STATE OF NORTH CAROLINA
DEPARTMENT OF TRANSPORTATION

August 25, 2024

MEMORANDUM TO: Division Environmental and Construction Units

SUBJECT: Environmental Permits for the Improvements to NC 150 in Catawba and Iredell Counties Division 12, **TIP: R-2307.**

SITE 10

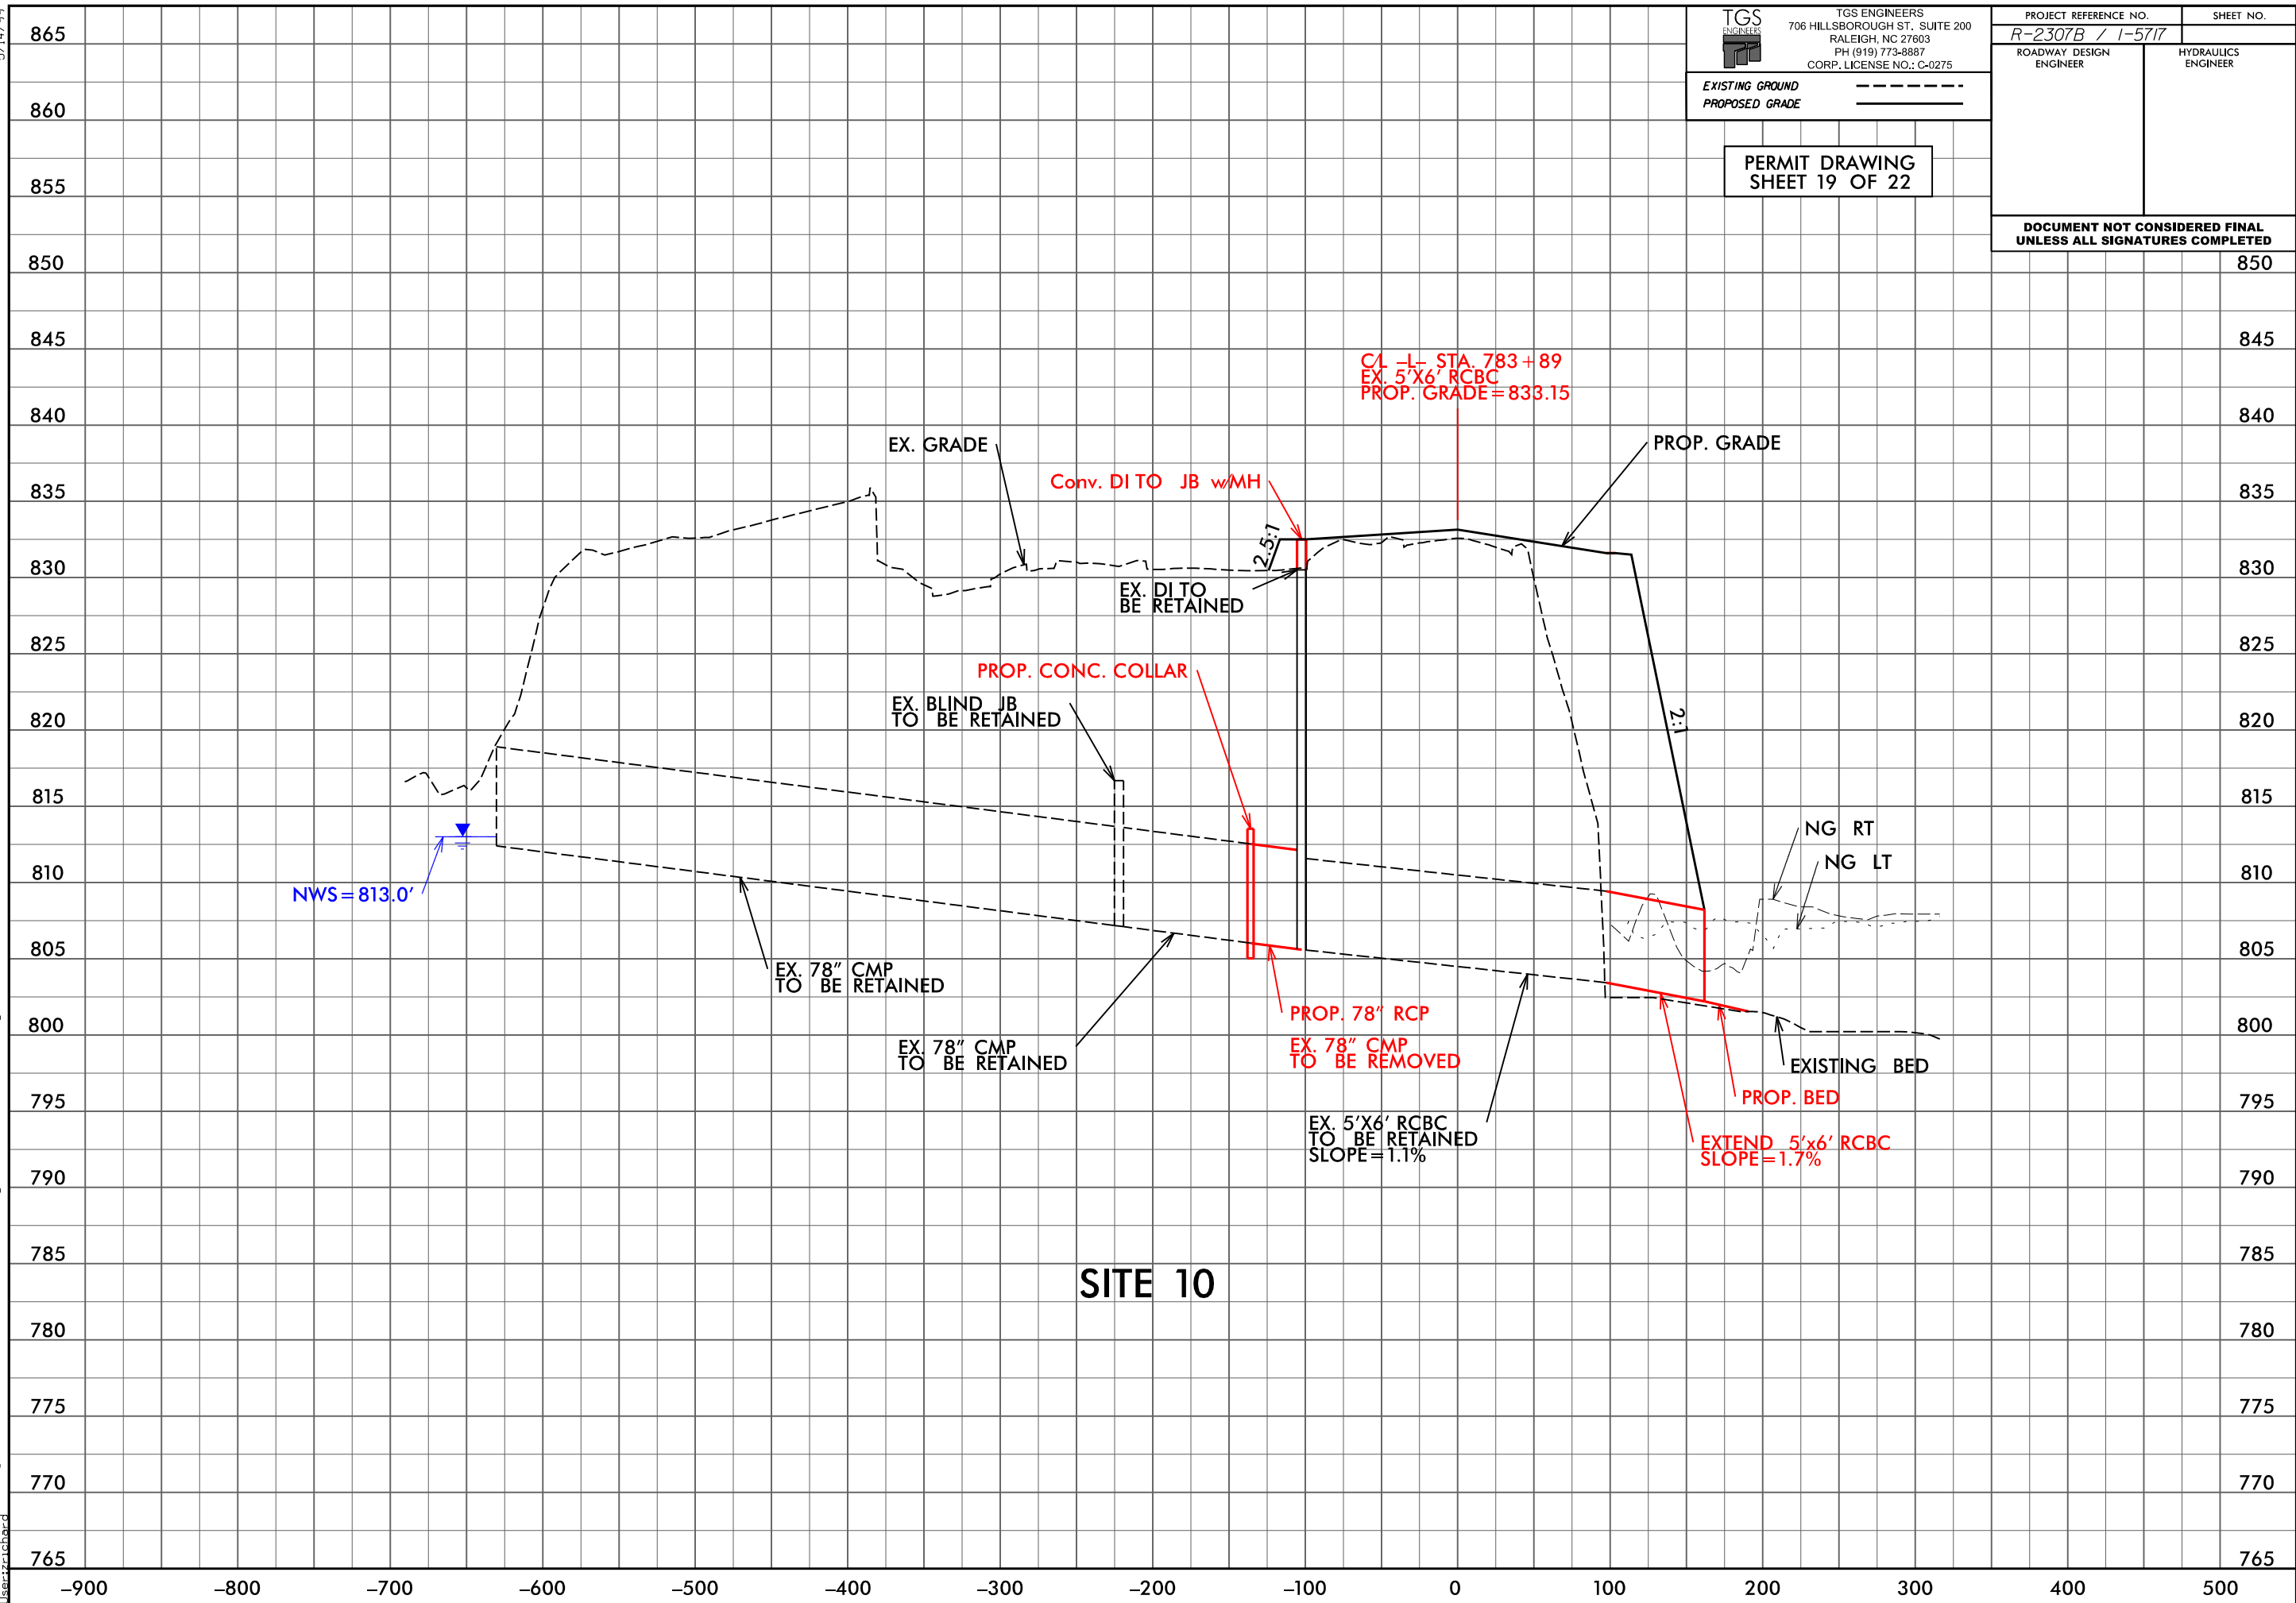
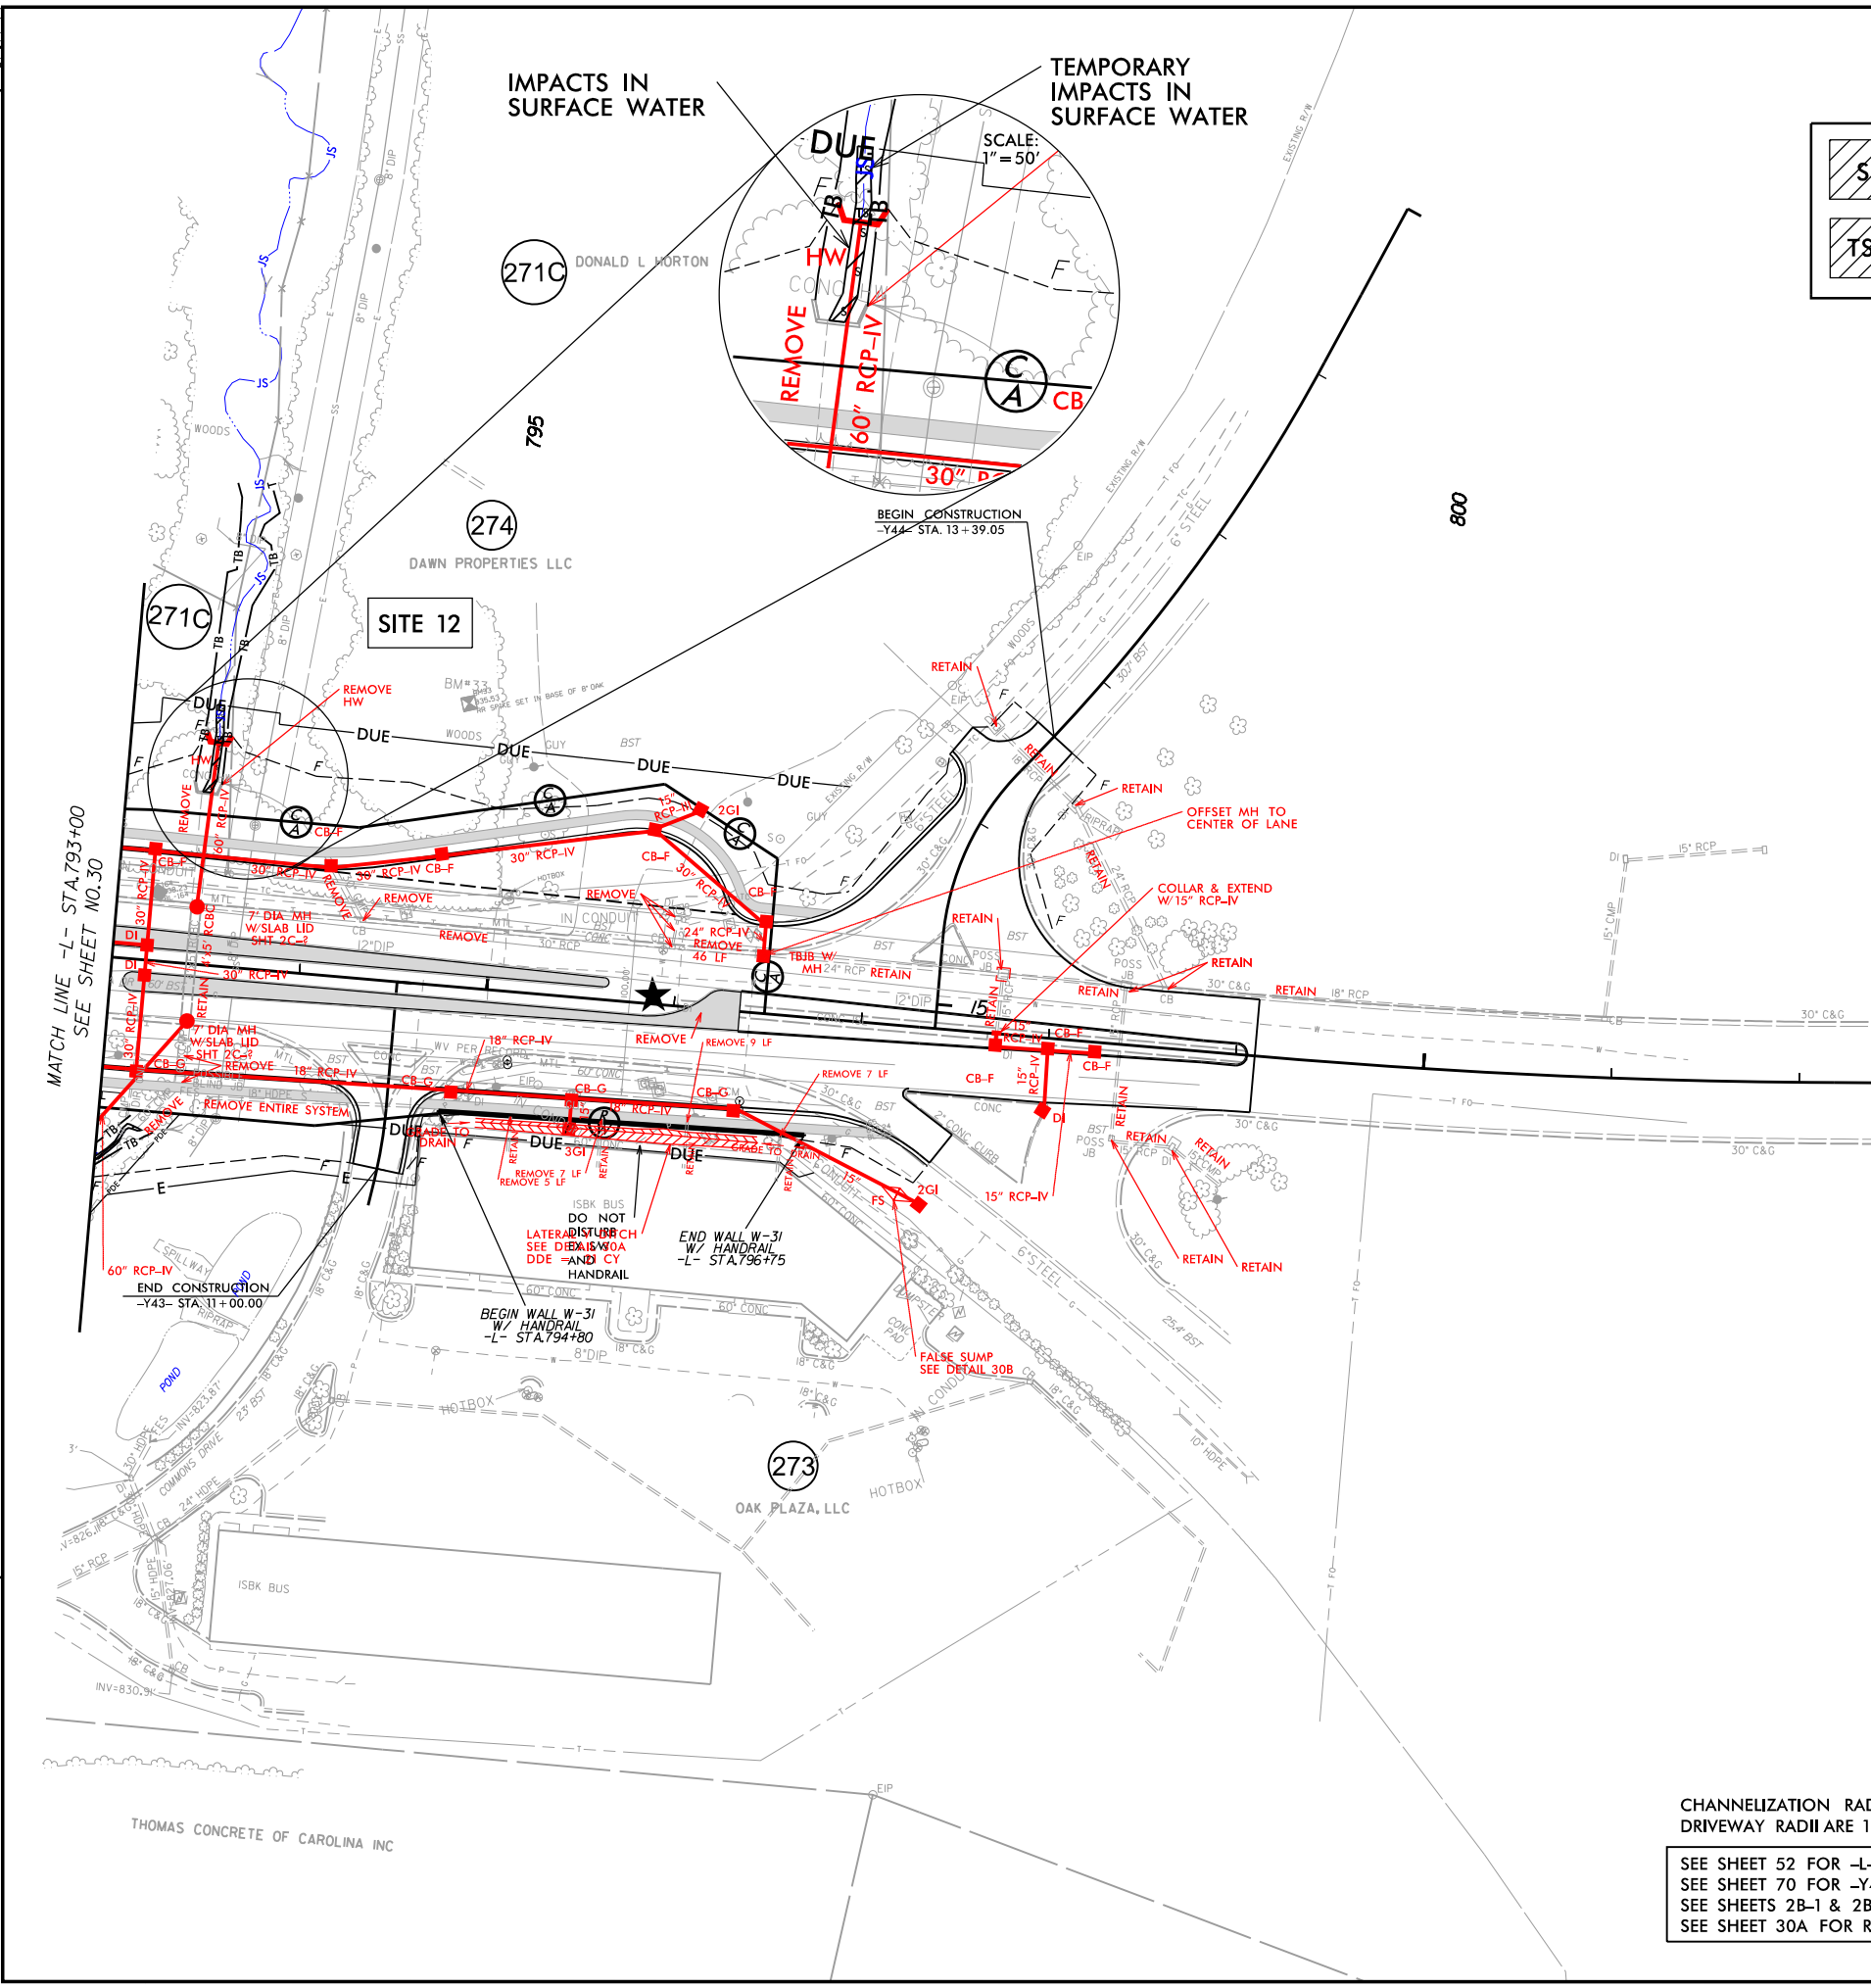
Site 10: The previous design proposed a 9' diameter precast manhole connecting an existing RCBC to a proposed 78" RCP at the downstream culvert extension at 784+50 RT (Permit Site 10). NCDOT determined that attaching a precast manhole to the existing RCBC is not feasible and would require a cast in place connection. To avoid this situation, the existing 5'W x 6'H RCBC will be extended. This will result in the outlet of the RCBC shifting 3' west of the previous 78" RCP outlet. However, the inverts, lengths, and channel layout will remain the same. There are no changes to stream impacts.
